## Appeal Decision

### Appeal Ref: APP/R5510/D/24/3355798

### **Khayri House, 70 Clifton Gardens, Hillingdon, Uxbridge UB10 0EZ**

- The appeal is made under section 78 of the Town and Country Planning Act 1990 (as amended) against a refusal to grant planning permission.
- The appeal is made by MR Ruin Khayri against the decision of the Council of the London Borough of Hillingdon.
- The application Ref is 78907/APP/2024/1882.
- The development proposed is construction of a part single-storey, part two-storey side/rear wraparound extension and a front porch, following demolition of existing front porch and side extension.

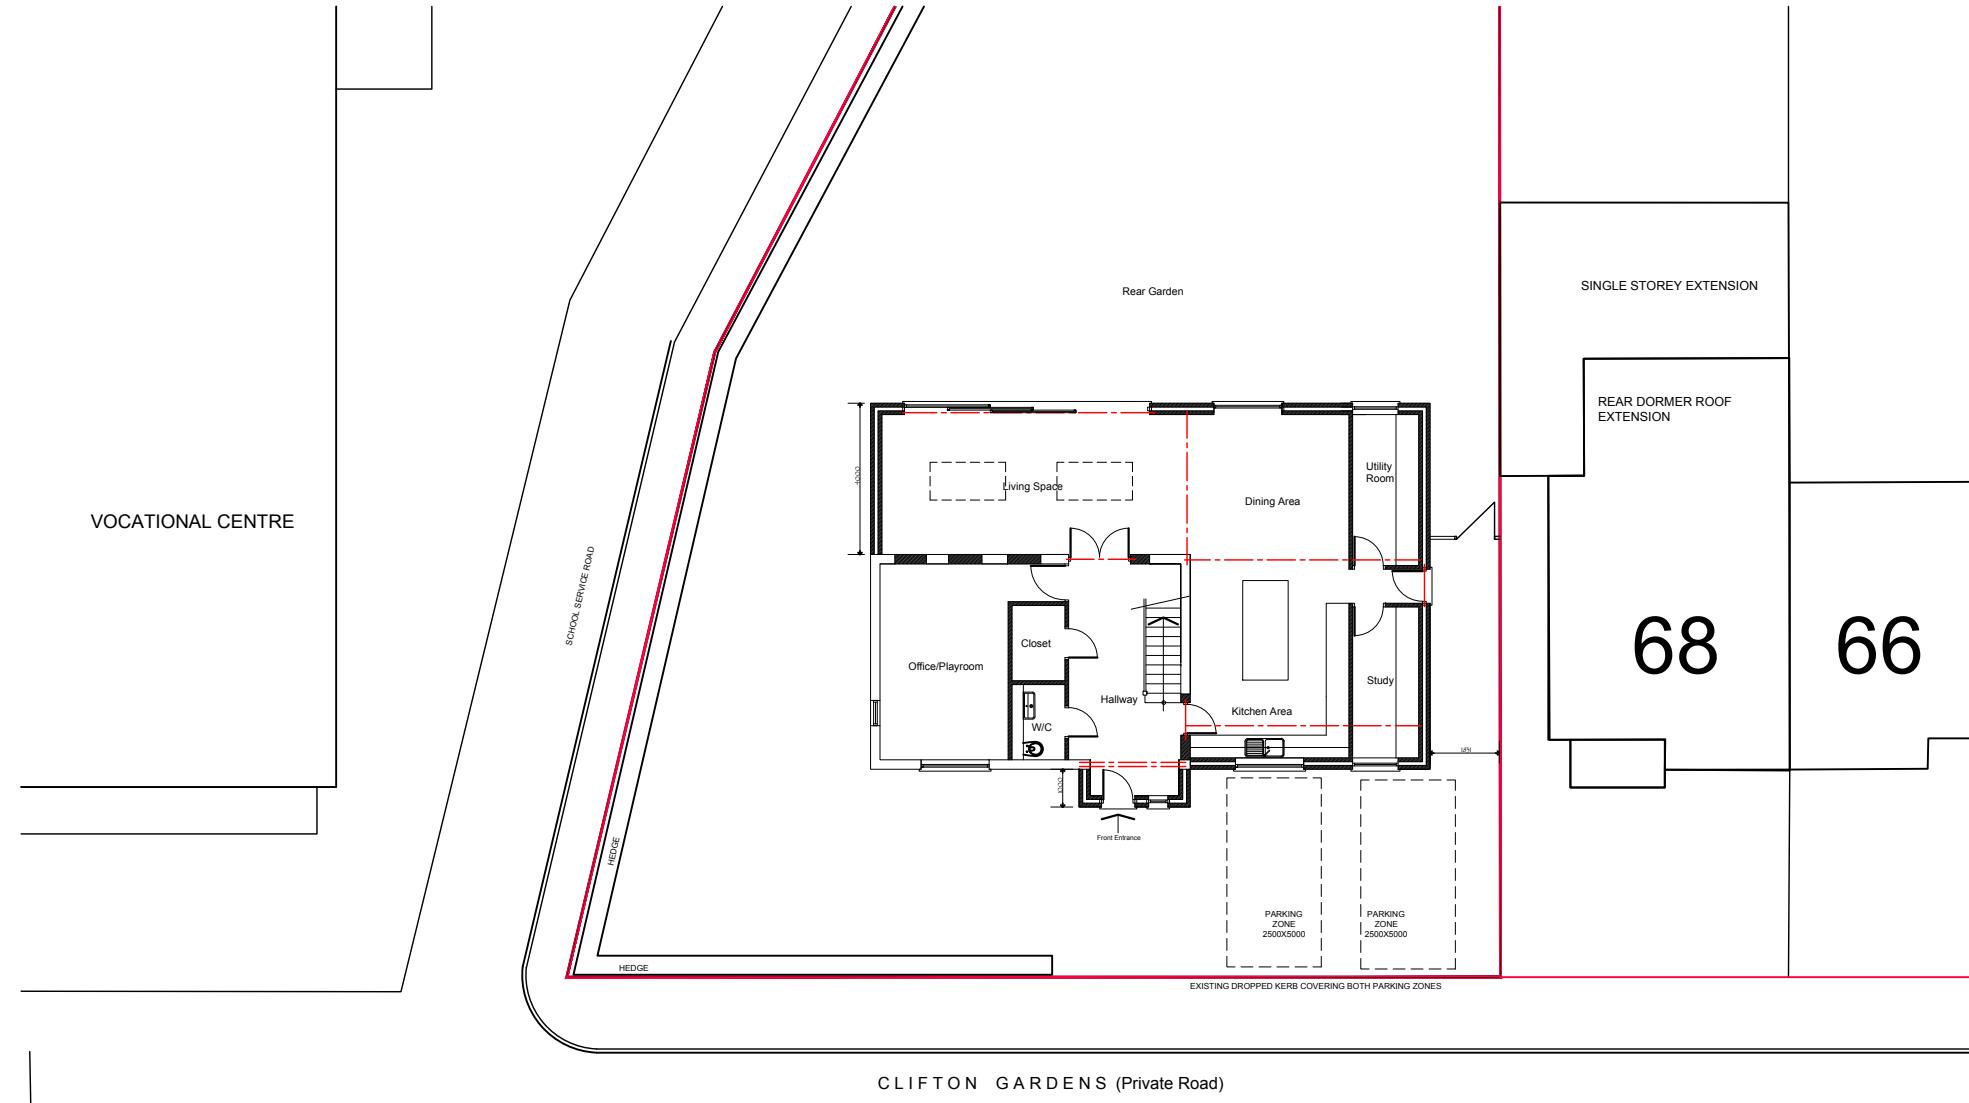
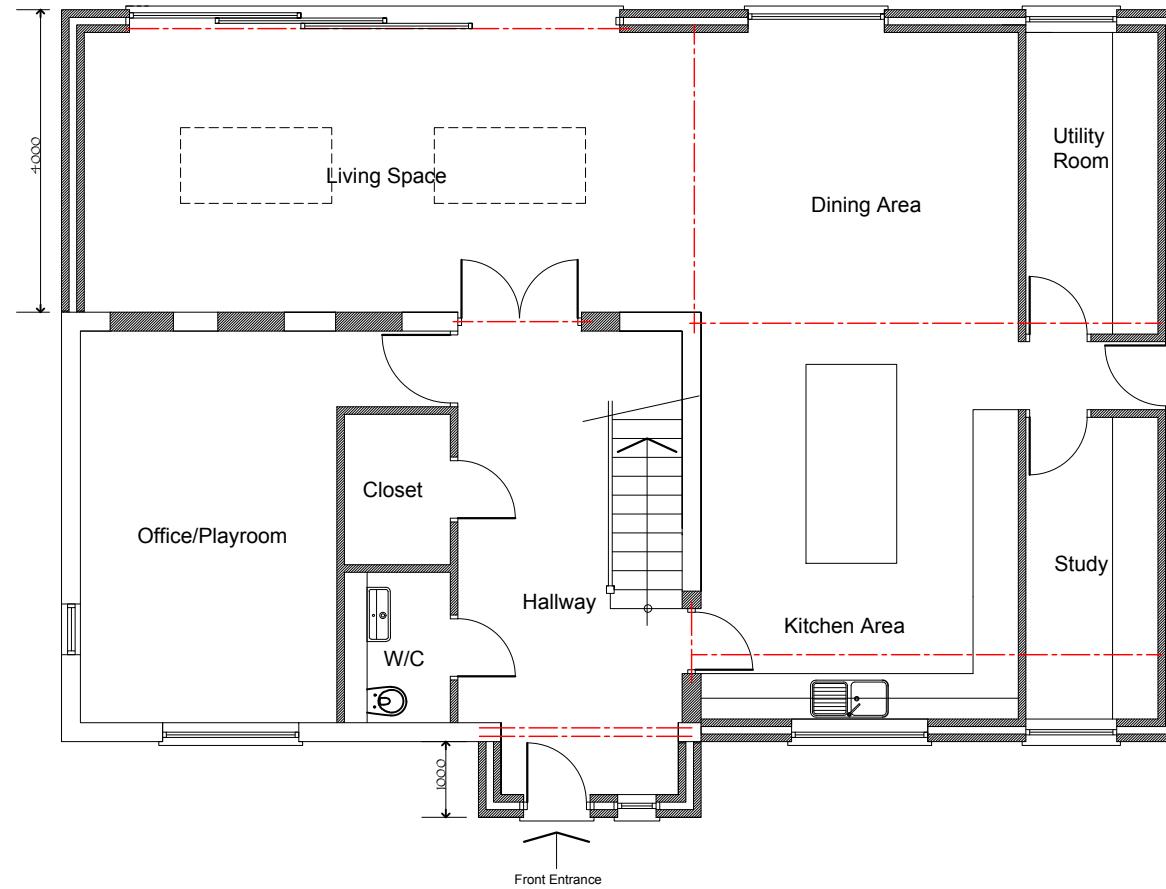
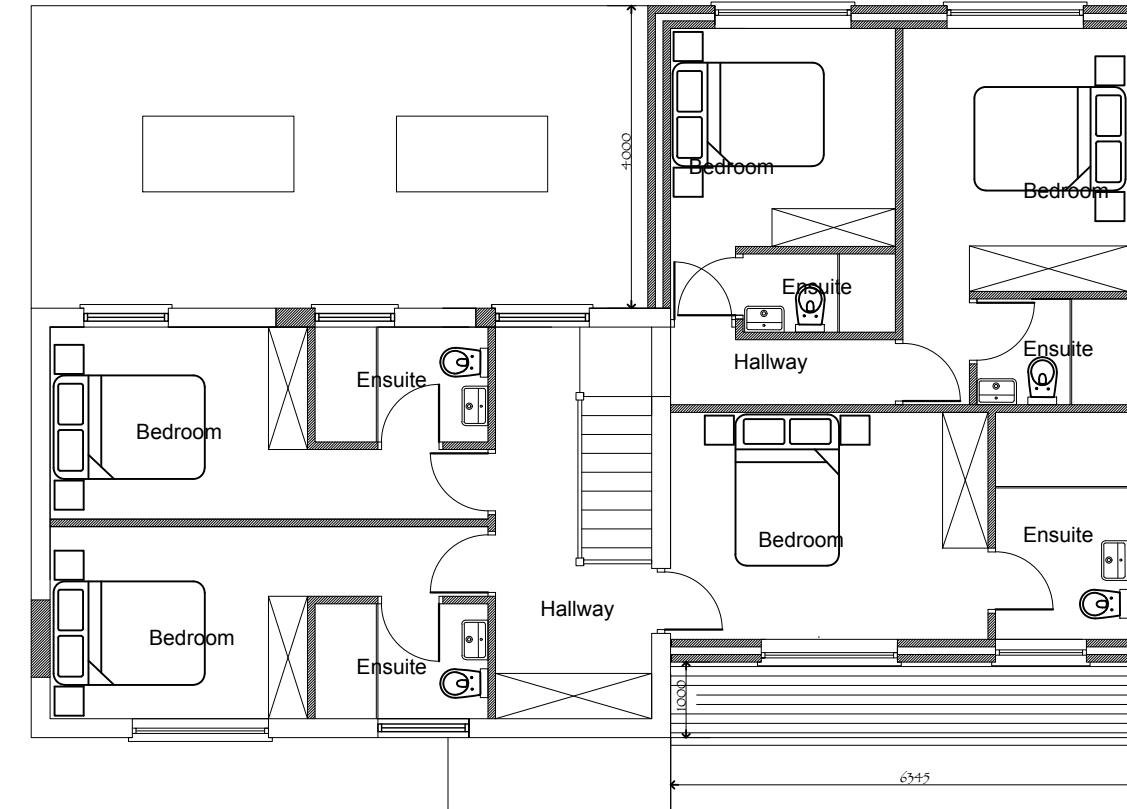
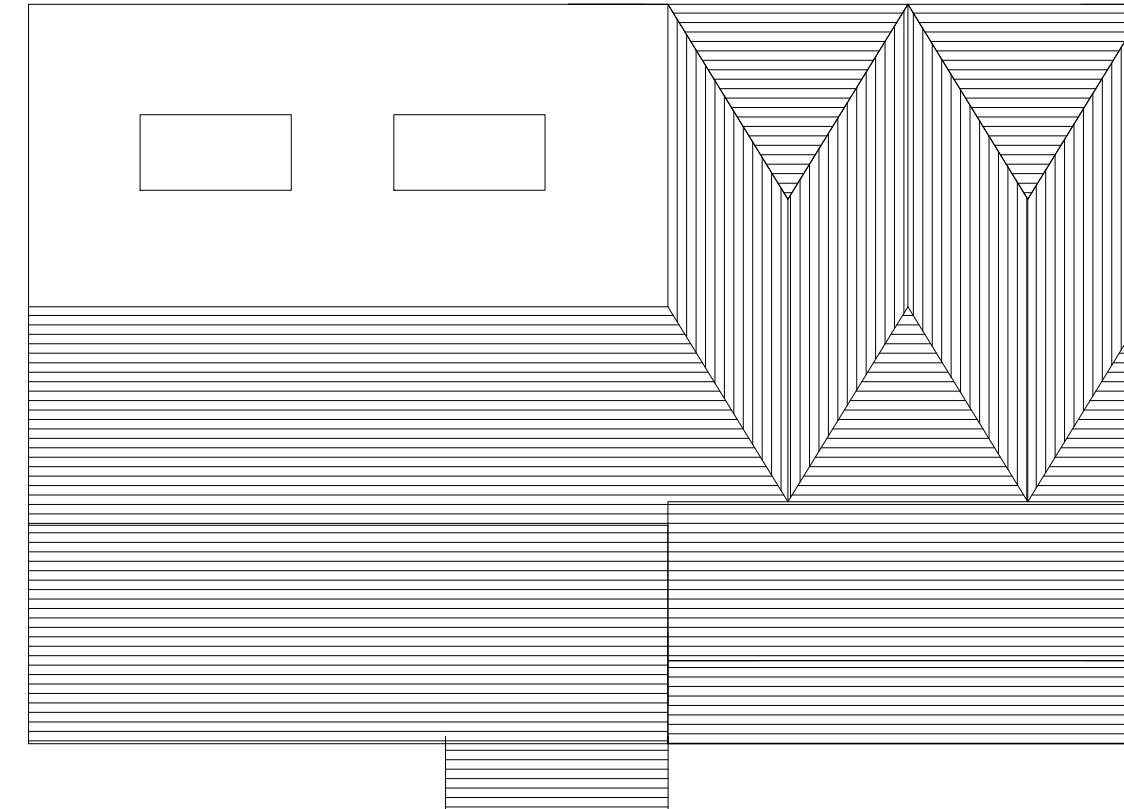
7. The appellant does not contest the Councils assessment that the proposed extensions would result in a 129% increase in floor area compared to the existing dwelling, and also increase the width of the two-storey element of the property by 6.3m. These are significant increases in both respects. Moreover, I have been provided with very little from the appellant to explain why they feel this would result in a proportionate addition. Given the above, I find that the proposed development would result in a disproportionate addition over and above the size of the original building. It would be inappropriate development in the Green Belt.

Drawing name:
Proposed Elevations

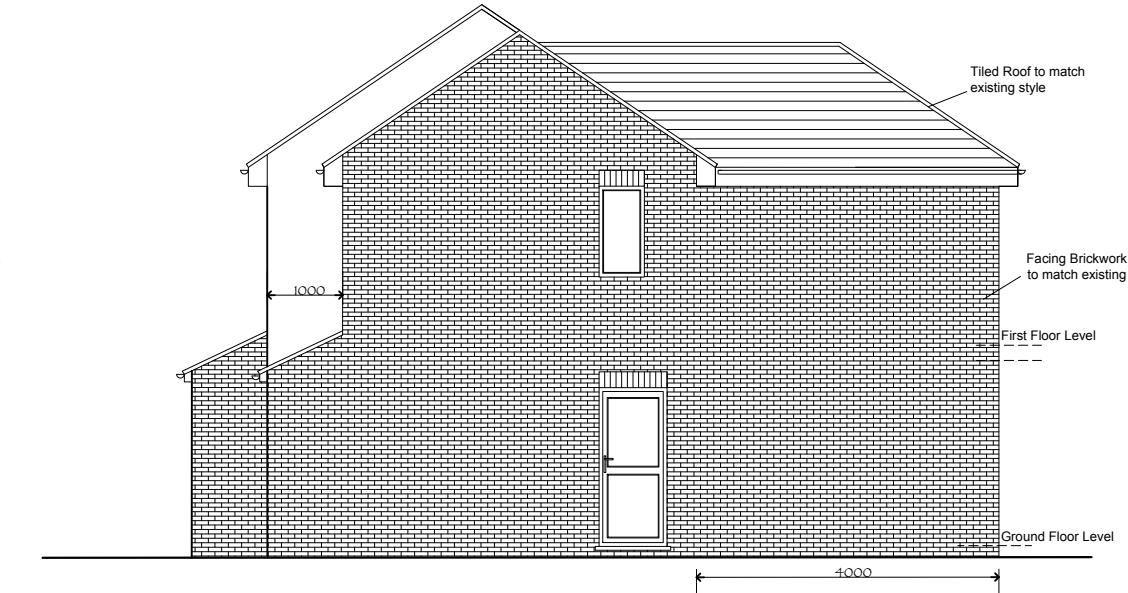
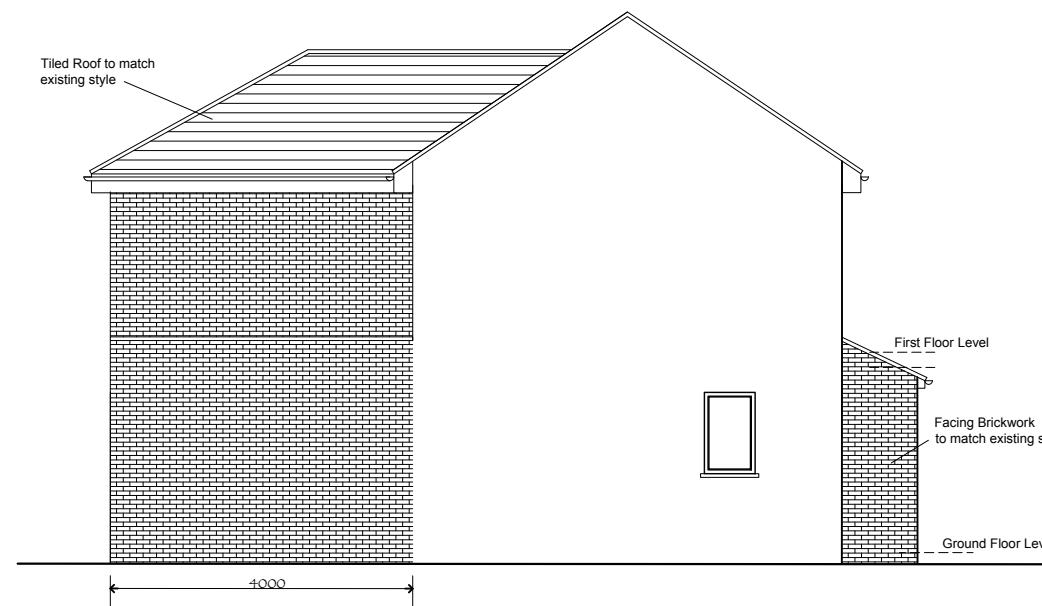
11. The proposal would result in a building with little in common with its neighbours in a design sense, but that is the position already, so no harm would arise. The proposed extension would be subservient to the host dwelling insofar as it would be set down at the ridgeline, and back from the front elevation at first floor level.

The roof form would be traditional, and matching to the host, and suitable external materials could be ensured via the imposition of planning conditions. A gap would be left to the western boundary, similar in width to that left by No 68 Clifton Gardens on the other side. This would maintain a reasonable distance between the dwellings.

12. Whilst the width of the two-storey side element would increase the bulk, mass, and presence of the dwelling, this would be mitigated by the subservient and complementary features described above.
13. The proposal would not harm the character and appearance of the host building and surrounding area, and would comply with the pertinent requirements of Policies BE1, DMHB 11, DMHB 12, and DMHD 1 of the Hillingdon Local Plan.
